Submission on the Airly Mine Extension Project EIS (State Significant Development 5581)

By Dr Haydn Washington, on behalf of the Colo Committee, October 2014

**Figure 3.3:
Water Management
Schematic**

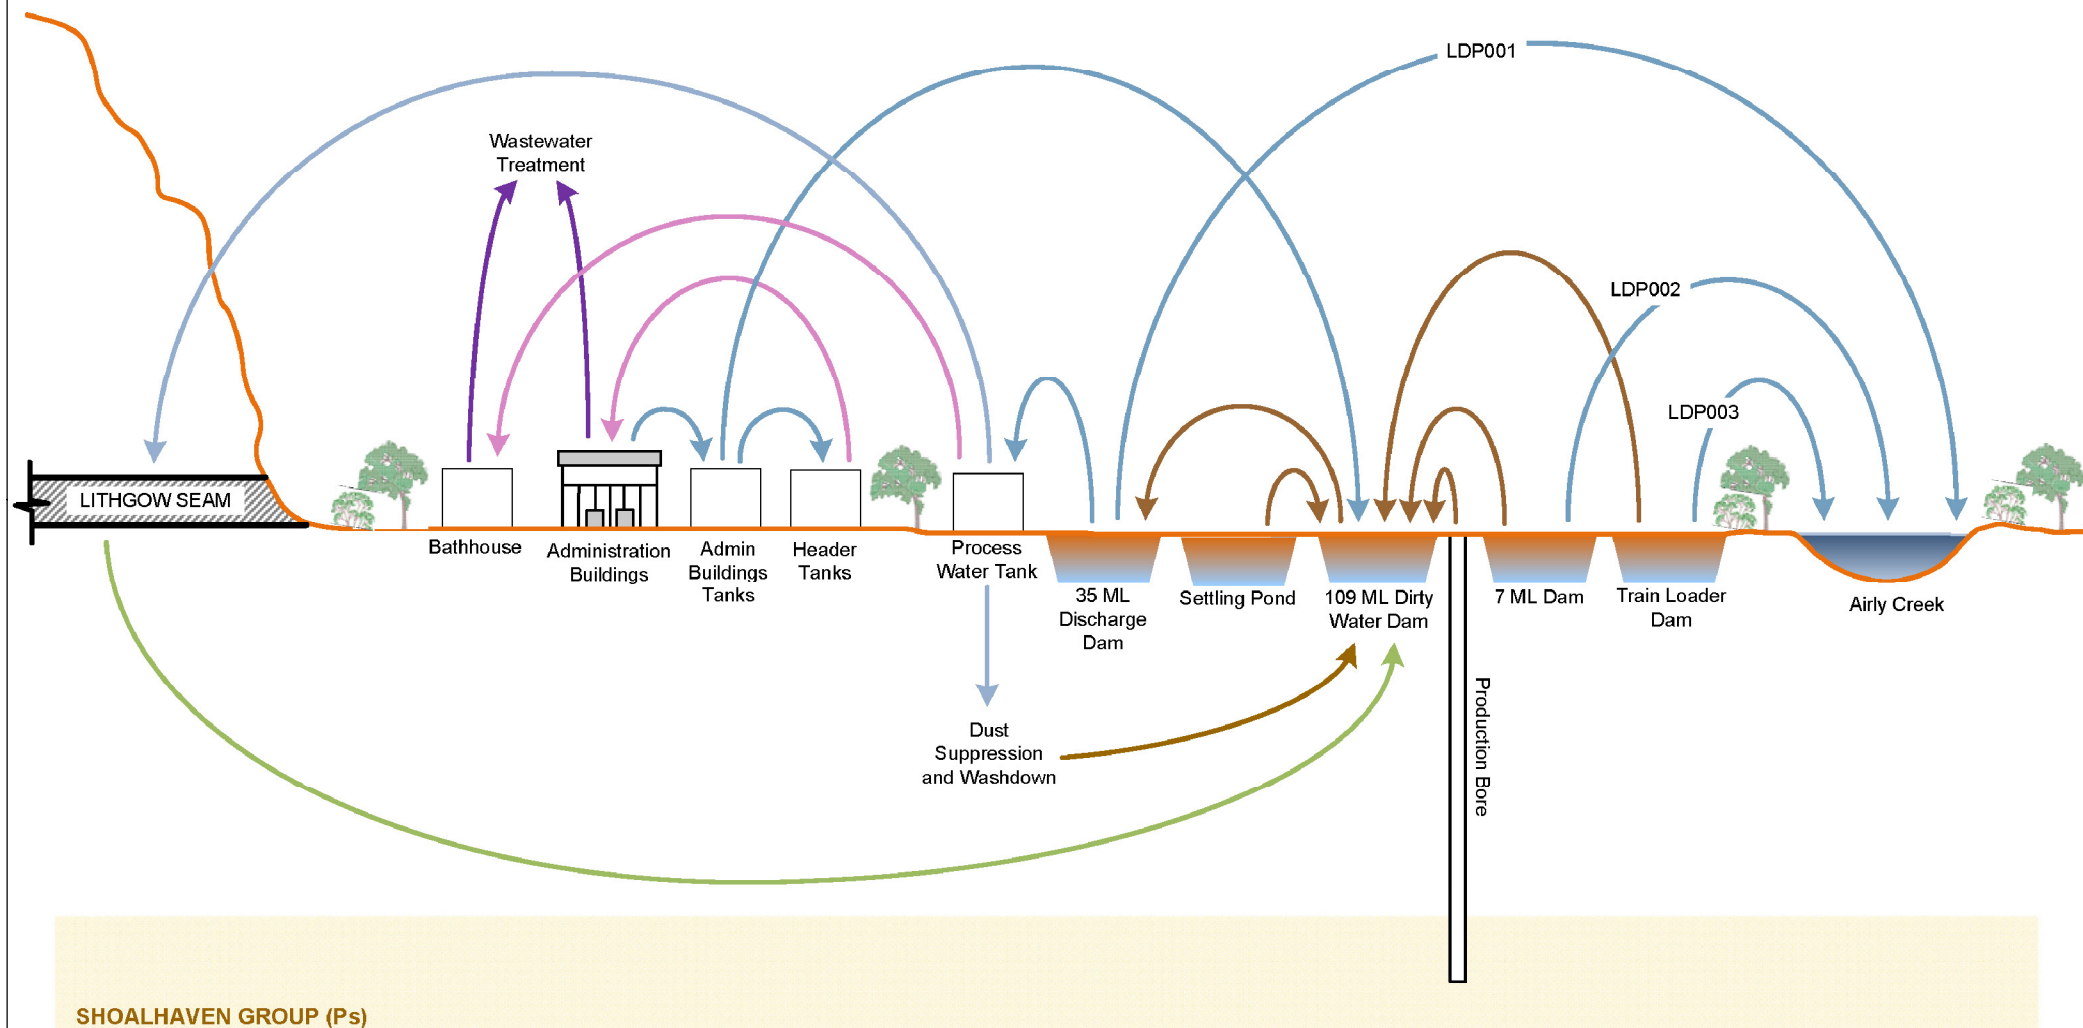
The current water management system is unsatisfactory as it mixes clean surface water with site runoff water and also combines these with mine effluent from the underground workings. This is a most unsatisfactory arrangement and contrary to any standard practice for water management for the last thirty five years. The arrangements are clearly illustrated on pages 100 and 101 of the EIS. Even the production bore water goes into the large dirty water dam, along with the water from the CPP. Centennial Coal does not explain its water management in section 3. Why are clean and dirty waters mixed with mine effluent in the largest storage on the site? Surely it is better to minimise the dirty water and the mine effluent, so that these waste waters can be first used as operational process water, as is proposed for runoff from the reject emplacement area. The REA water is proposed to go to the 109ML large storage dam.

The water management plan needs to be rethought so that the dirty water is sorted SEPARATELY and used in preference for mine process water. Any overflows from these separate storages should then be diverted to the large storage dam. This would be a far better arrangement to minimise discharge of toxic water from the site, rather than risk maximising it, albeit in diluted form.
